Application for a non-material amendment following a grant of planning permission.

Number	
Suffix	
Property name	Land opp 233 Broadgate
Address line 1	Weston Hills
Address line 2	
Address line 3	
Town/city	Spalding
Postcode	PE12 6DQ
Description of site location must be completed if postcode is not known:	
Easting (x)	527630
Northing (y)	319608
Description	Erection of 3 dwellings H22-1271-18 non material amendment

Revised internal layout of Plot 3 to included minor external elevation amendments, and minor re-positioning of Plot 1, to increase distance between Plots 1 and 2.

Title  
PROPOSED FLOOR PLANS & ELEVATIONS  
PLOT 3

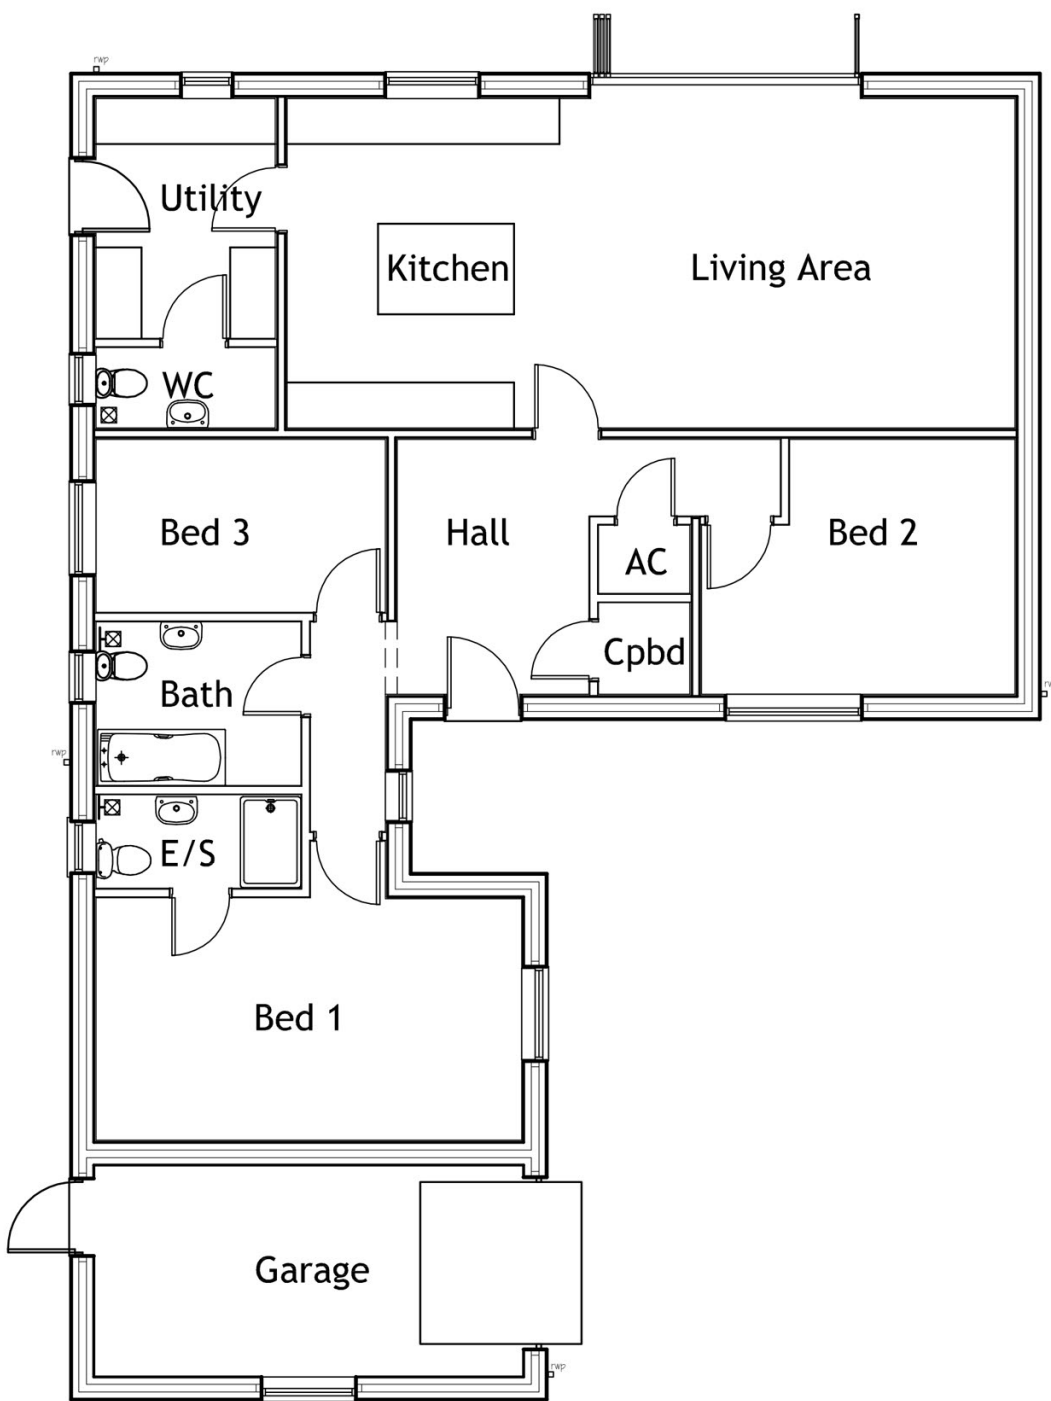
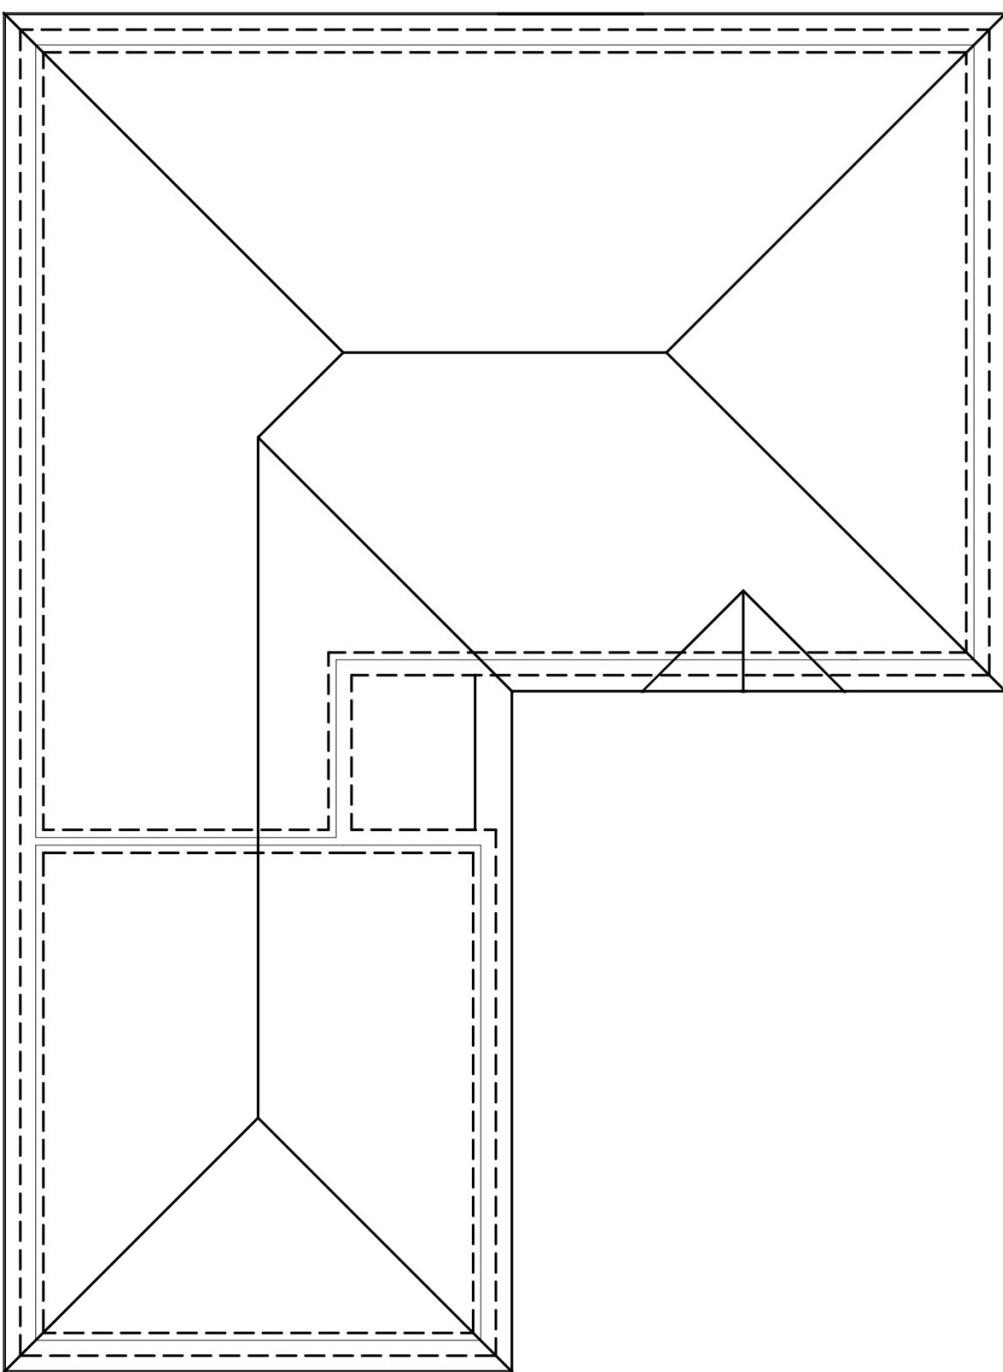
Amendments for prospective purchaser for Plot 3, and to increased separation between plots 1 and 2.
